Re: Drainage Plan 715 Aspen St. NW

Report, As Built

715 Aspen Av N. W.
Storage Building for the Statkus Brothers

Re: STATKUS BROTHERS DRAINAGE REPORT

DRAWN BY: RDZ	STORAGE BUILDING
	CHECKED BY: RLH	FOR
	REVISIONS: REL 6/15/81	THE STATKUS BROTHES
	REV 8/14/81	
	REV 9/9/81	DRAINAGE PLAN
	AS BUILT ELEV. ()	
	1/15/82	RAY HARRISON & ASSOCIATES

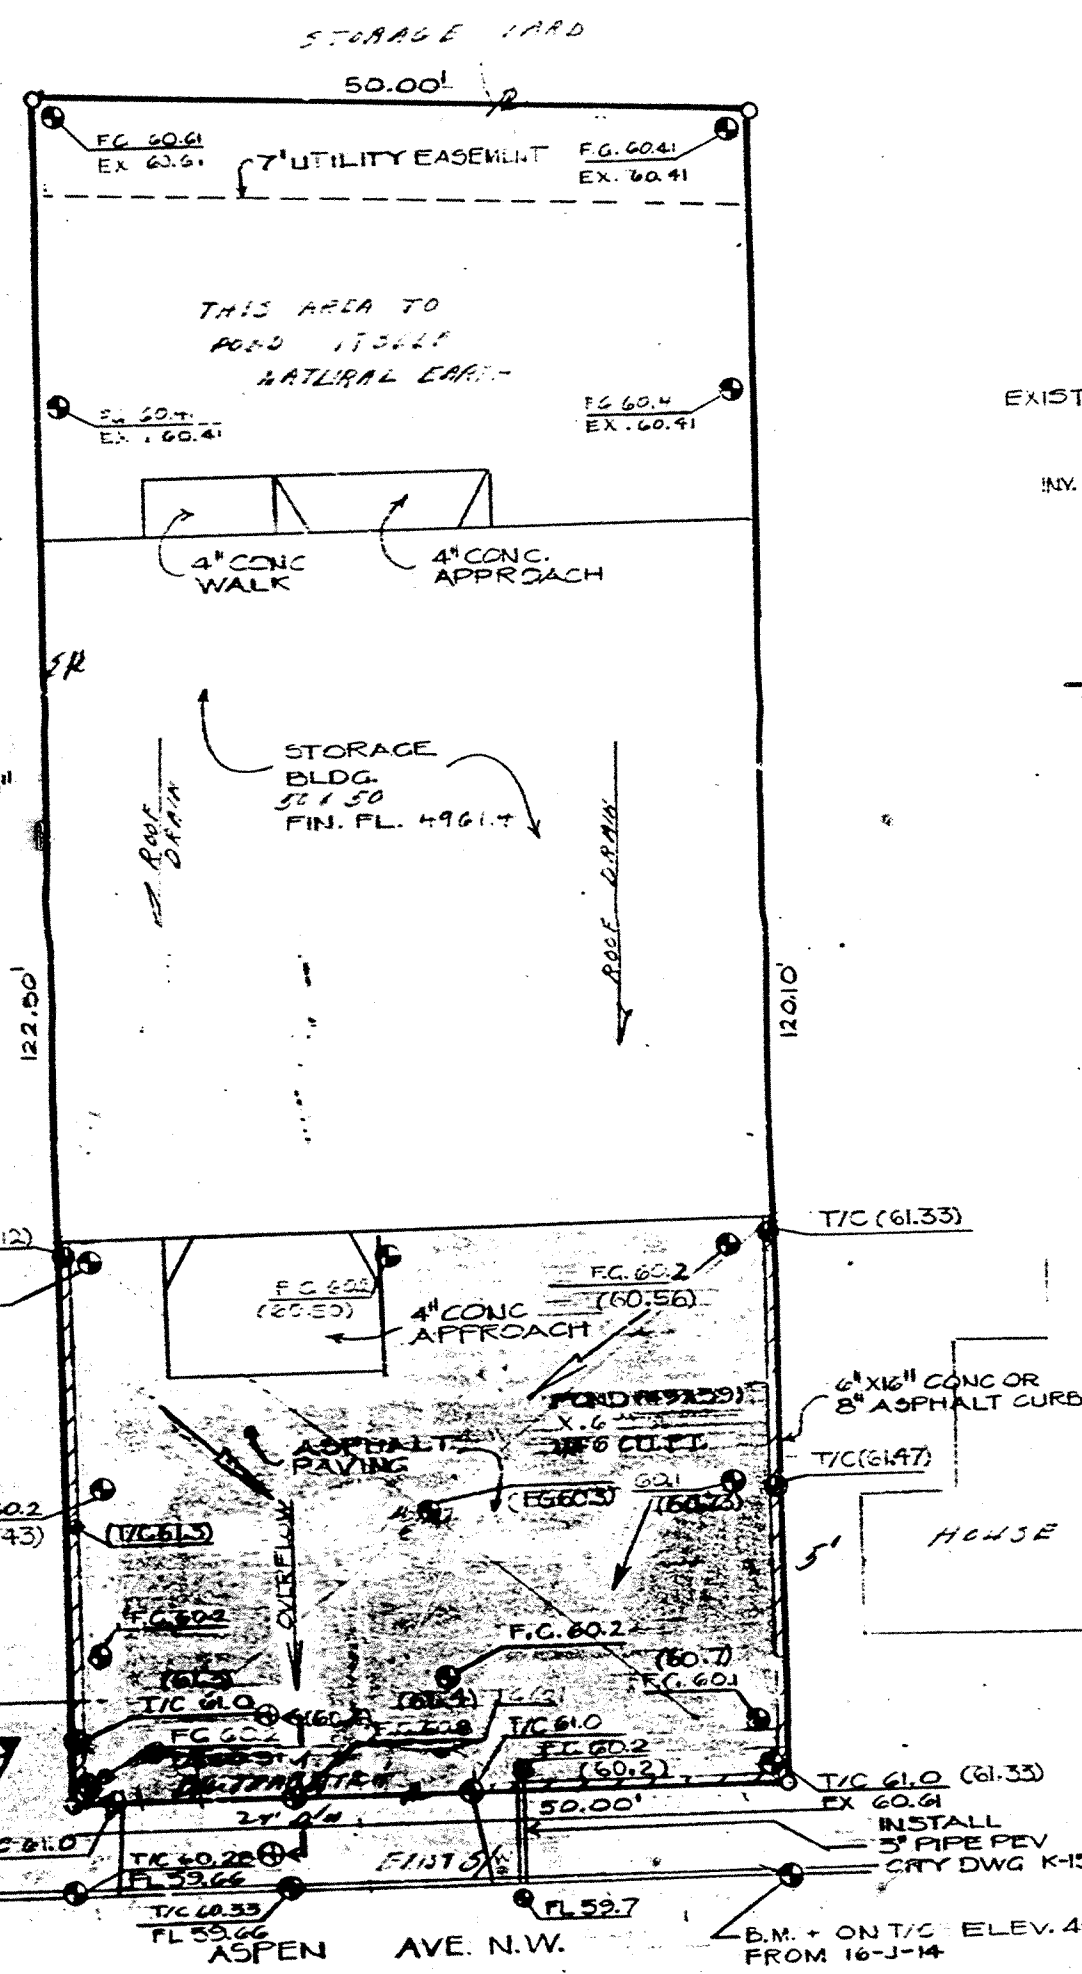
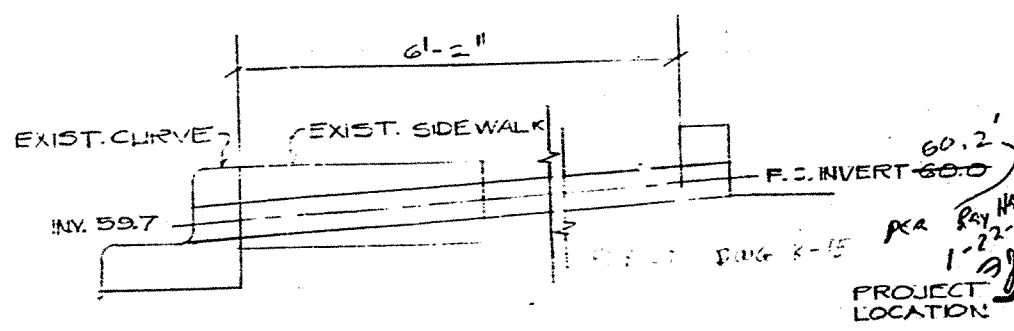
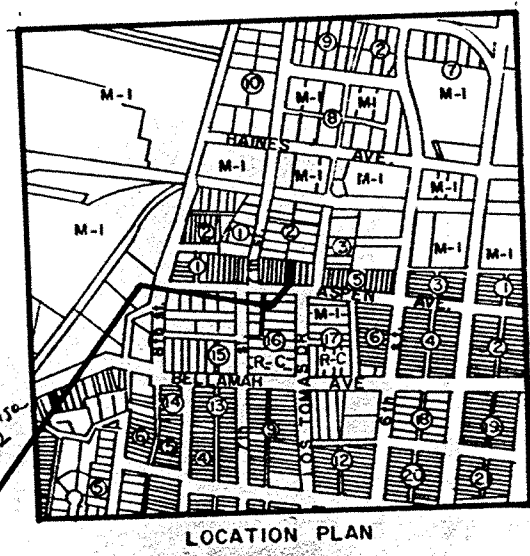
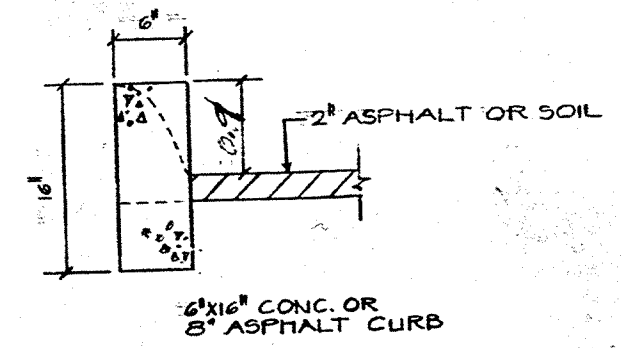
Enclosed is an as built drawing of the referenced project. It has an average depth of .8' as called for in the report and will provide the required ponding of 1090 Cu. ft. The driveway spill way is 0.2' below the curb and will act properly. Approval of this project is recommended.

Ponding of 1090 Cu. Ft. was required on the approved
plan. Ponding provided is about 600 cu. ft. because
of construction errors.

DISAPPROVED FOR DRAINAGE
1-11-02
DATE
SUBMITTER COMPLIANCE
REQUIRED

Final approval is recommended because the lot was
previously developed (old house), the new construction
is a vast improvement over the old construction and
the drainage feeds into a storm sewer system that has
adequate capacity (7th Street). In small lots such
as this it is practically impossible to have a convient
driveway and provide much ponding.
